From: Contact Centre (CRM) <contact@ribblevalley.gov.uk>
Sent: 13 March 2026 14:23
To: Planning
Subject: Planning Application Comments - 3/2026/0021 FS-Case-811928961

Planning Application Reference No.: 3/2026/0021

Address of Development: 41 - 43 Wellgate Clitheroe

Re: 3/2026/0021 - Change of use of upper floors to create four flats and external alterations - 41-43 Wellgate Clitheroe BB7 1LU

SHEET:
PROPOSED ELEVATIONS

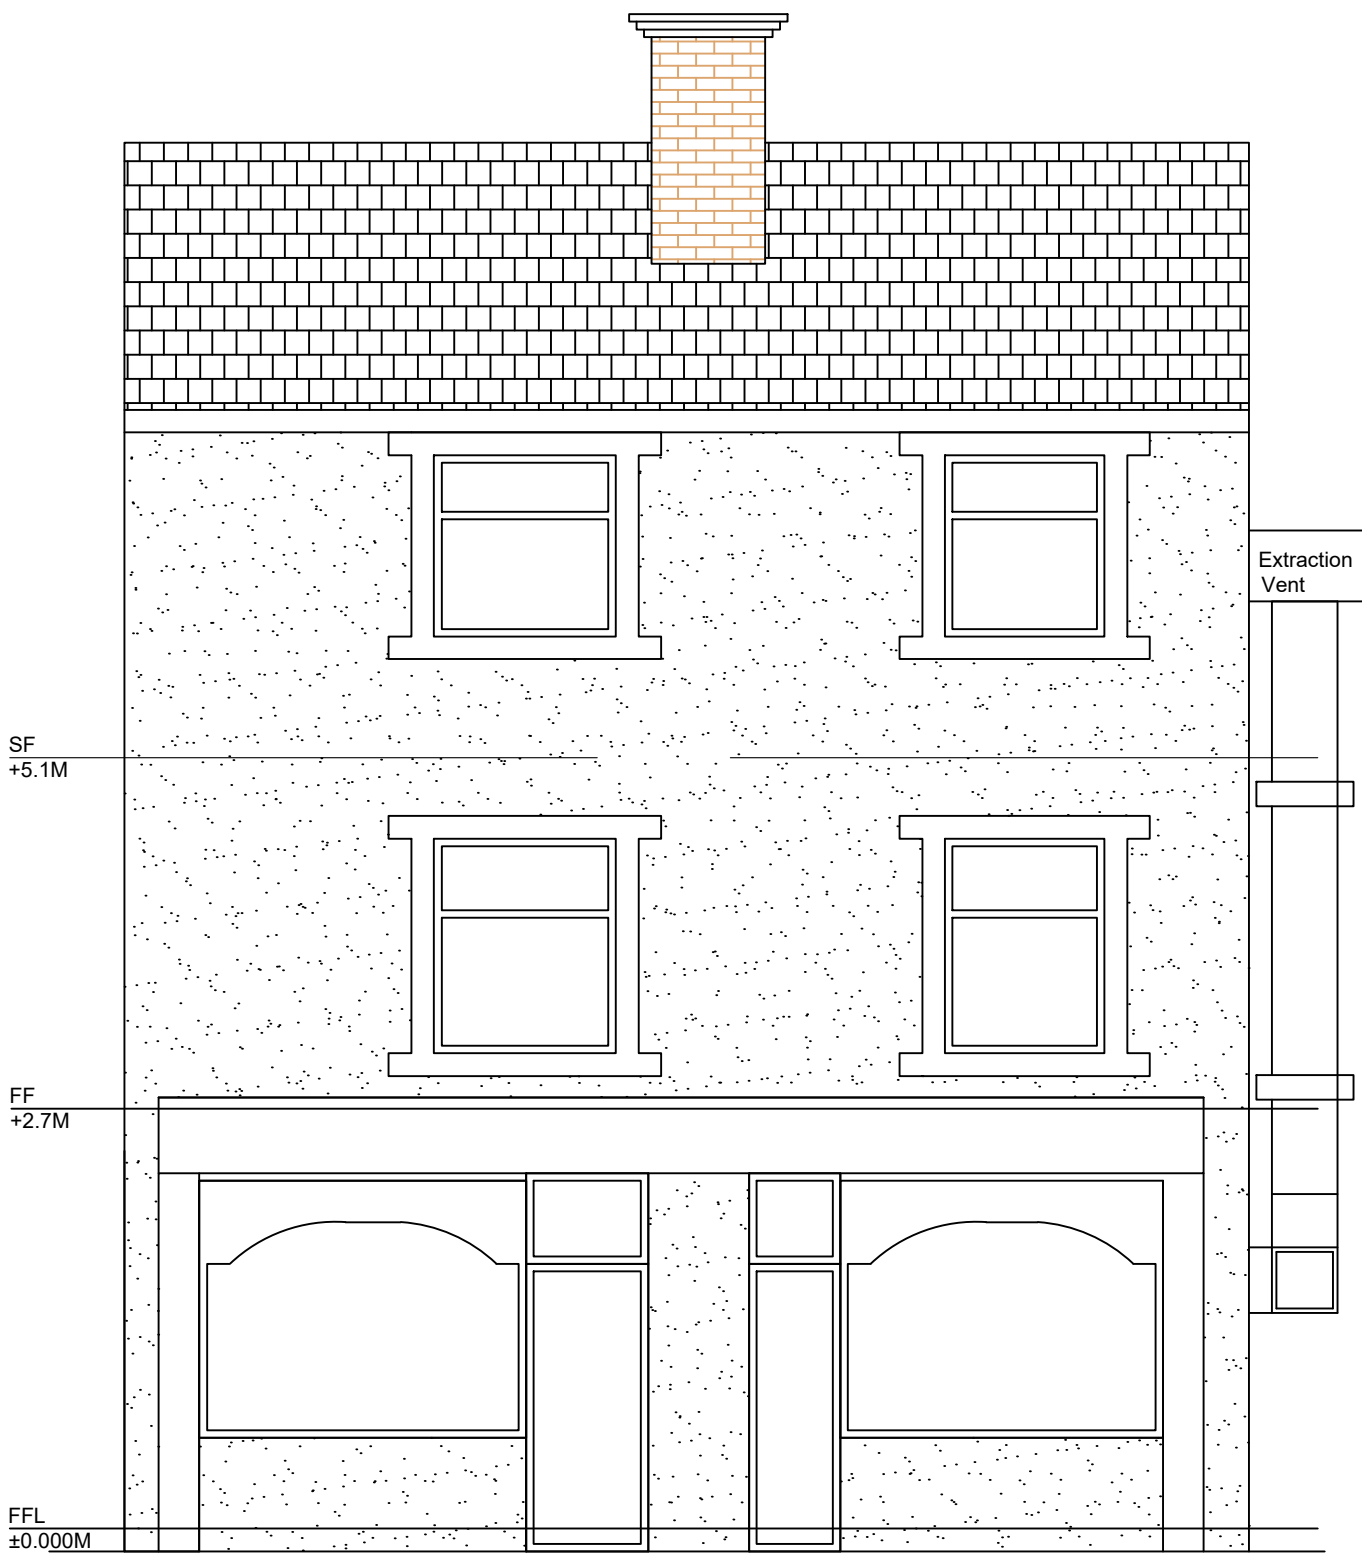
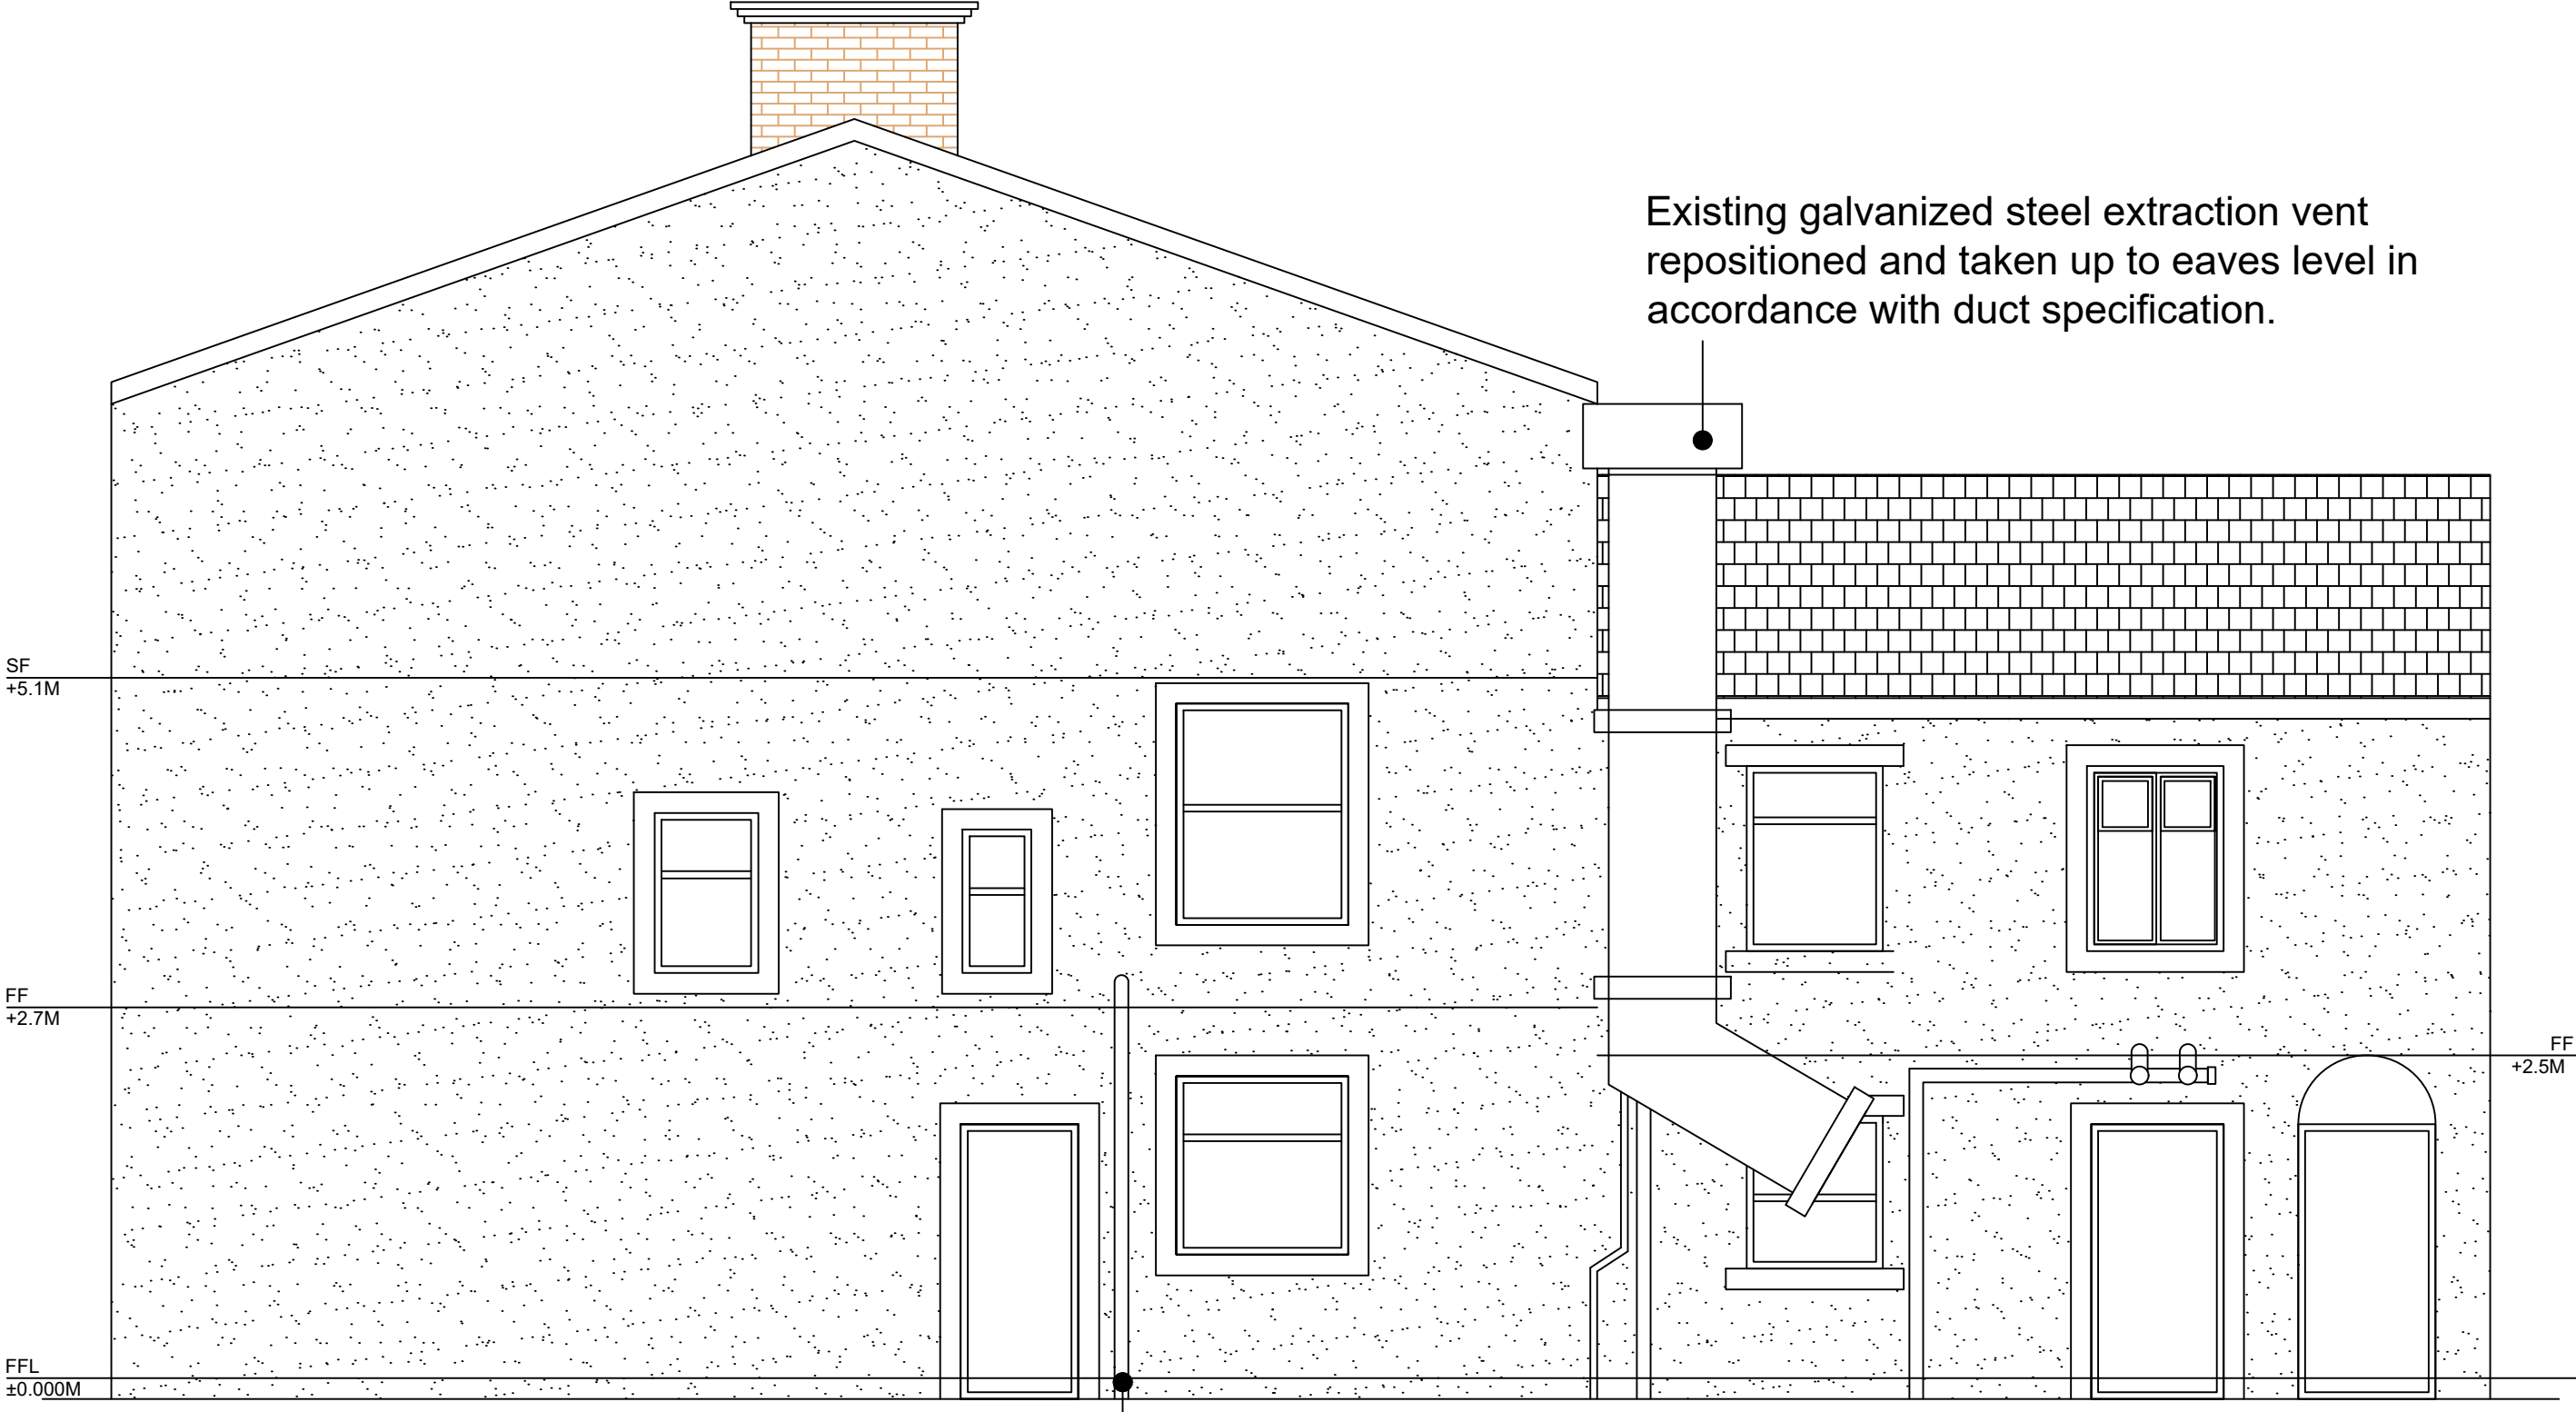
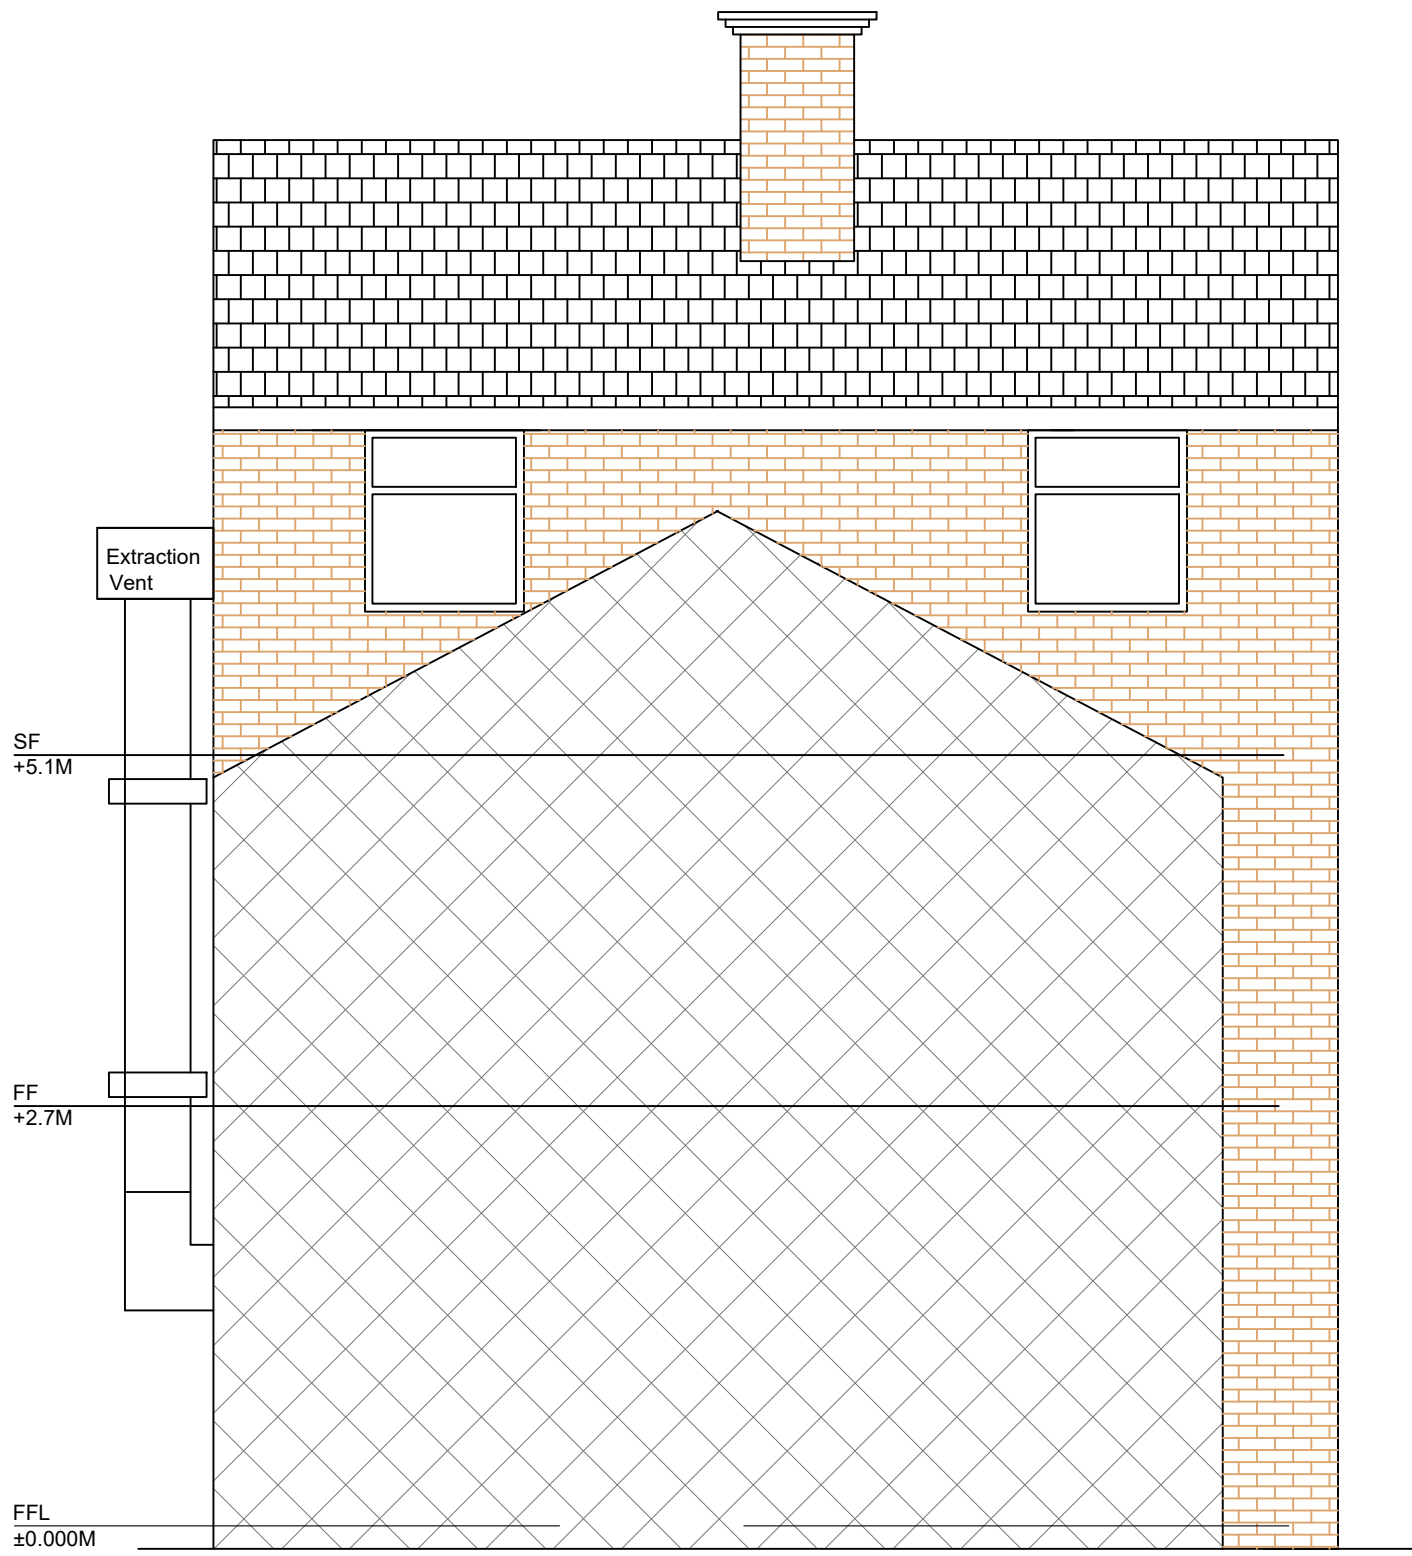
The Design and Access Statement refers to triple-glazed windows, while the Heritage Statement refers to the refurbishment of sliding sash windows, and the Acoustic Survey recommends standard double-glazed units.

Proposed elevation drawings do not show any changes to the windows. Clarity on the type of windows should be provided with the application. If double or triple-glazed units are proposed, then these should be of a style and materials appropriate for use in the conservation area to avoid harm to its significance and should be accompanied by sufficient justification.
